**RE: Harnett County Land Use Existing Tank Application # 16-5-39664R**

The Harnett County Department of Public Health, Environmental Health Division on 8/14/17 evaluated the above referenced property at the site designated on the plat/site plan that accompanied your existing tank application. According to your application requesting, **to move the distribution box**, the evaluation was done in accordance with the laws and rules governing wastewater systems in North Carolina General Statute 18A.1950 including related statutes and Title 15A, Subchapter 18A, of the North Carolina Administrative Code, Rule.1950 and related rules.

Based on the criteria set out in Title 15A, Subchapter 18A, of the North Carolina Administrative Code, Rules .1950, the evaluation indicated that the site is **UNSUITABLE** for the addition requested. Therefore, your request for an existing tank is **DENIED**. The site is denied based on the following:

**BOUNDARY EXHIBIT**

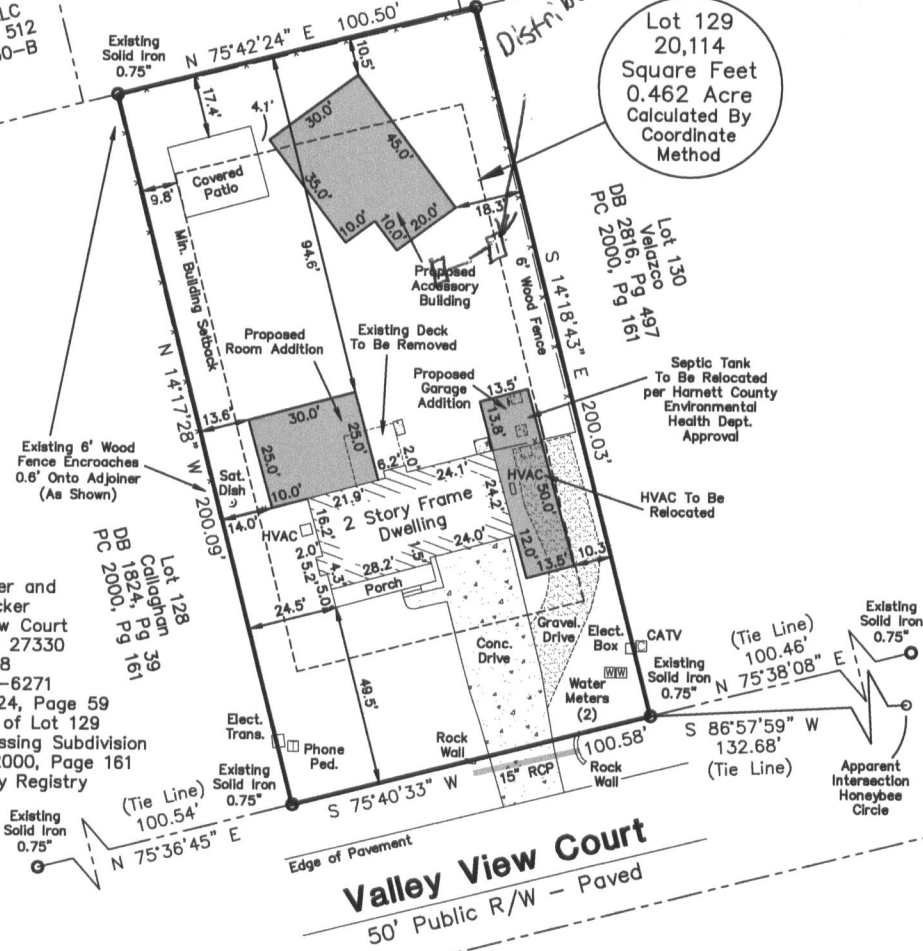
- \_\_\_\_\_ 15A NCAC 18A.1950a {16} - Any swimming pool must be 15' from any part of septic system.
- X   15A NCAC 18.1945{b} - Each lot shall have original septic system plus repair area.
- \_\_\_\_\_ 15A NCAC 18A.1950 {10} - Any building to be 5' from septic tank and/or from drain line. Drain Lines appear to run under proposed deck locations.
- \_\_\_\_\_ 15A NCAC 18A.1950{c} - Nitrification fields and repair areas shall not be located under paved areas or areas subject to vehicular traffic.

*You will need to revise you application at Central Permitting to reflect these changes.*
